Council Ref: Kincoppal Rose Bay School (HPE CM Folder: SC5907 Ref: 20/241876)
Planning & Development Division

29 January 2021

Application Number SSD-10325
Proposal name Alterations and additions to Kincoppal – Rose Bay School
Address 2 Vaucluse Road, Vaucluse

B12 SITE PLAN PRECINCT IDENTIFICATION

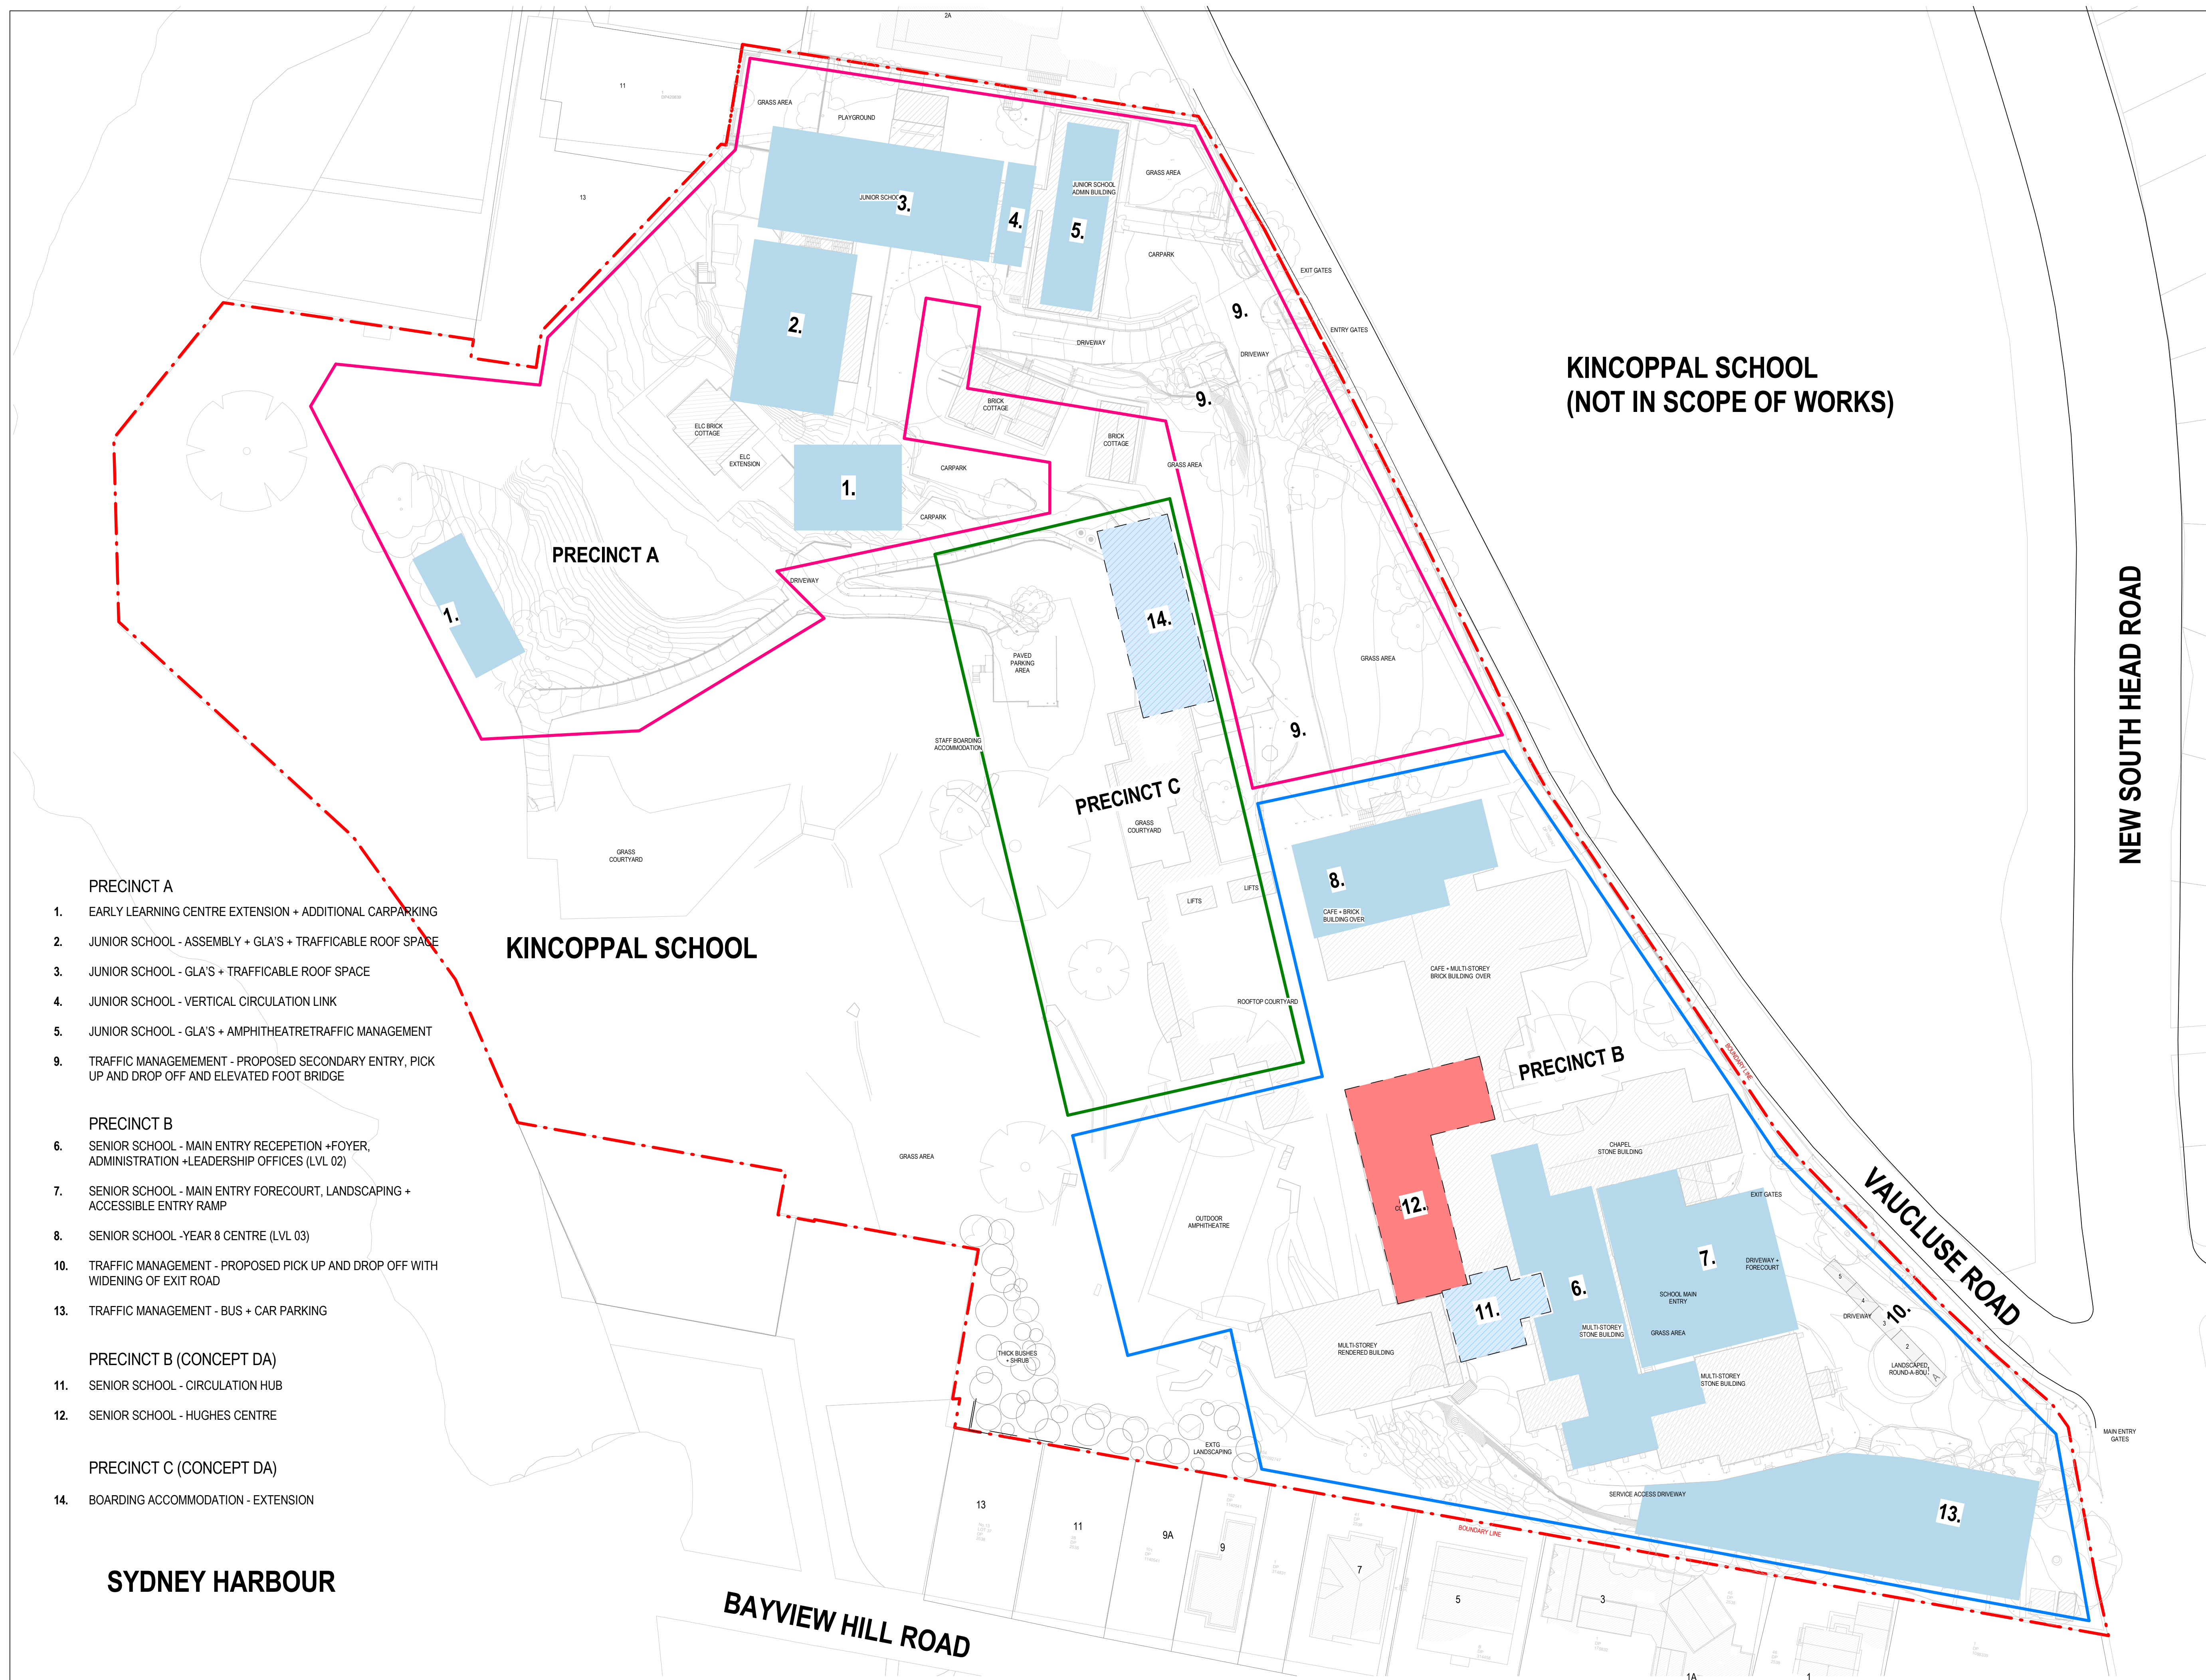
- i. The proposed additional bulk and scale for the existing boarding accommodation exceeds the maximum 9.5m Height of Buildings development standard prescribed by Cl 4.3 of the WLEP 2014 by 4.5m. Its conceptual footprint appears to be significantly larger than its neighbouring buildings to the west and north. It is recommended that the applicant provides a detailed analysis at the DA stage to demonstrate the proposal's compatibility with its surrounding context and its visual impacts on the existing public/private views.

PROPOSED ELEVATIONS -
EAST

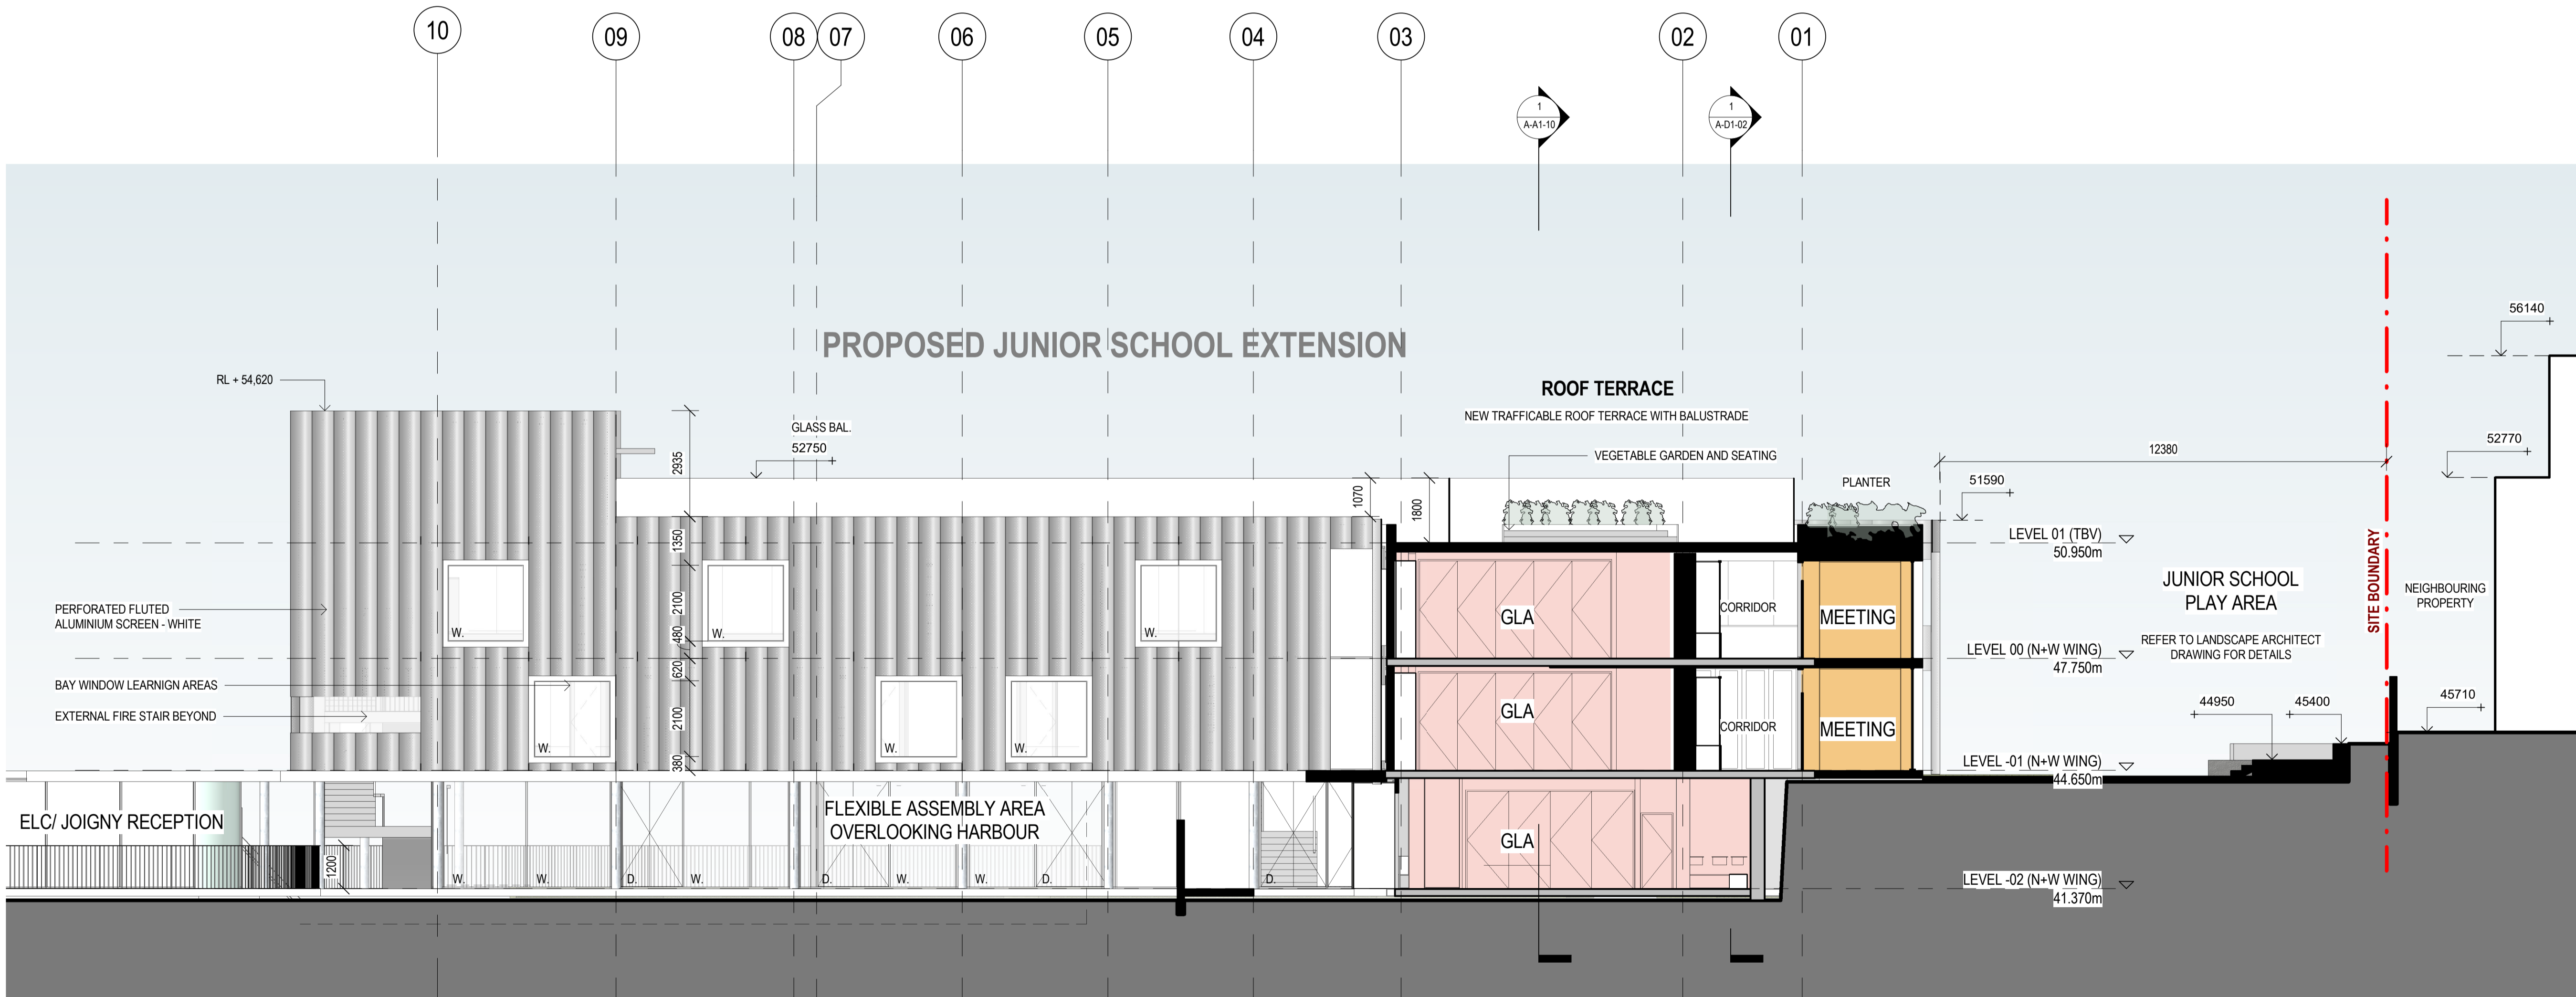
- 1) **Precinct A –**
- i. Concern is raised about the perceived bulk and scale of the proposed vertical circulation link to the Junior School. It should be redesigned to create a more articulated facade and enhance the transparency of the façade through materials and/or openings. This is to reduce its perceived bulk and scale and improve the façade visual interest, particularly when viewed from Sydney Harbour.

PROPOSED SITE PLAN

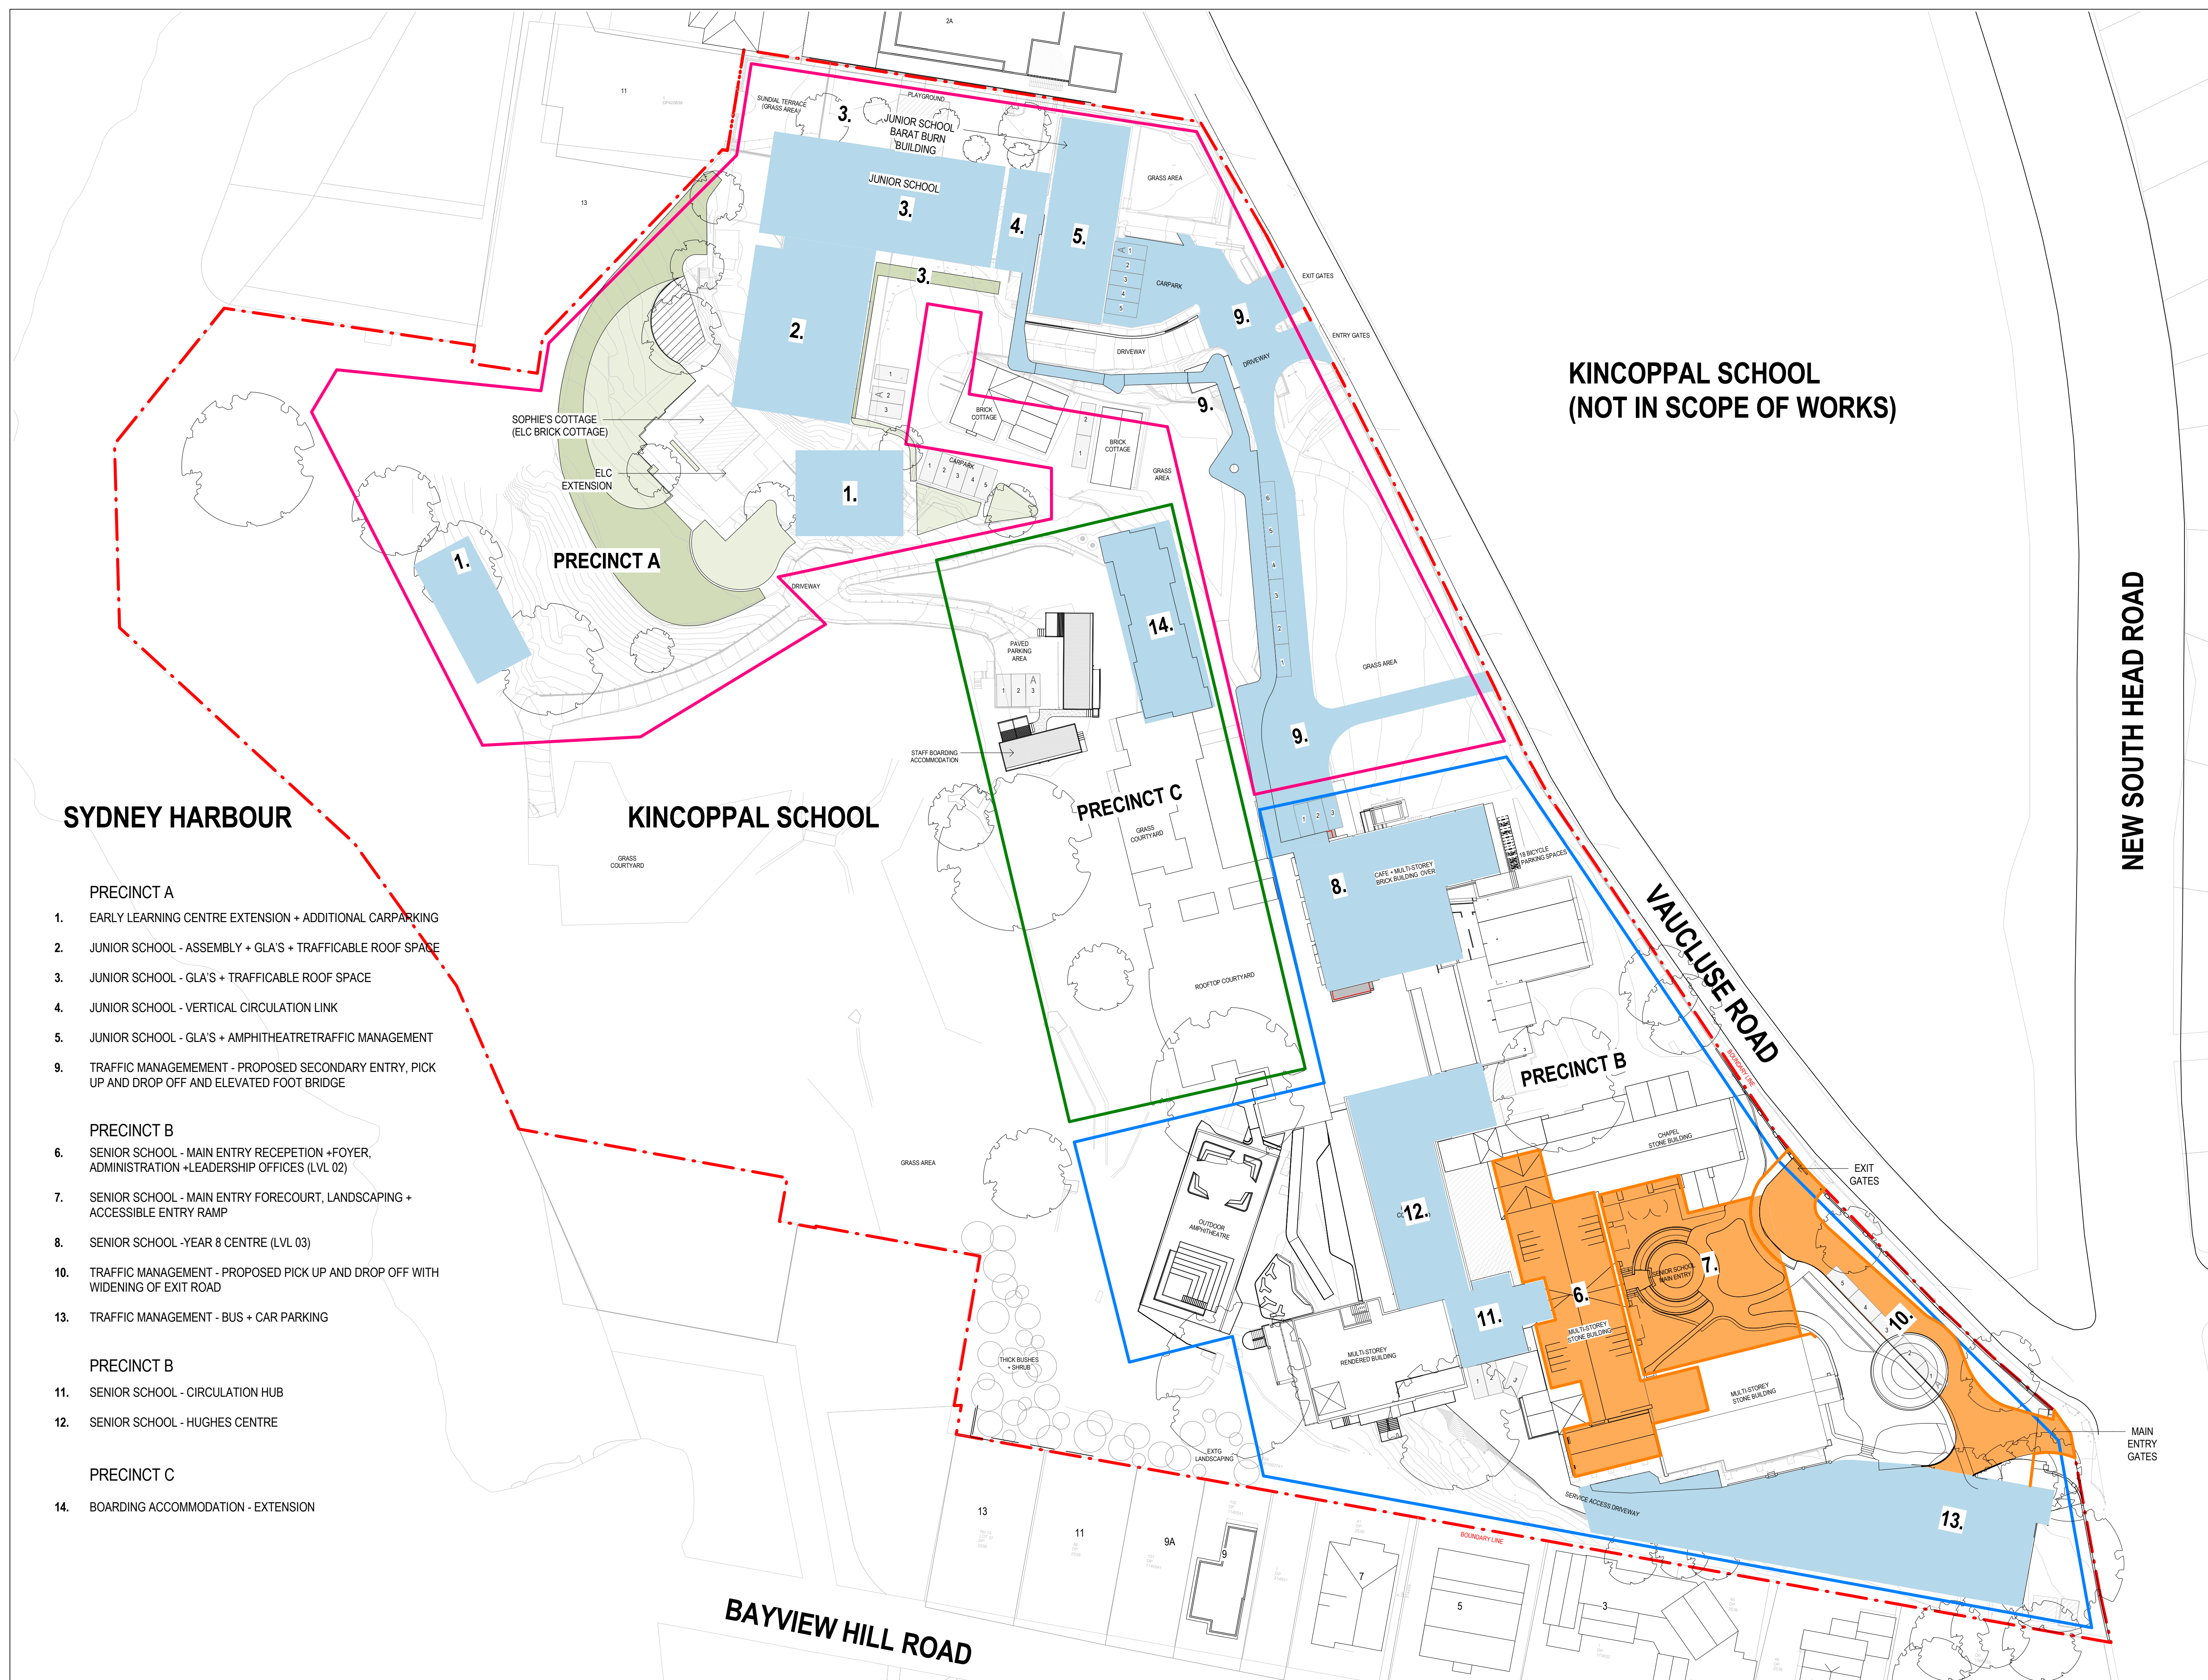
- 2) **Precinct B –**
- i. The proposed alterations and additions to the Year 8 Centre are not supported by Council’s Urban Designer, as it eliminates the views to the existing heritage building when viewed from Sydney Harbour and different vantage points in the subject site.
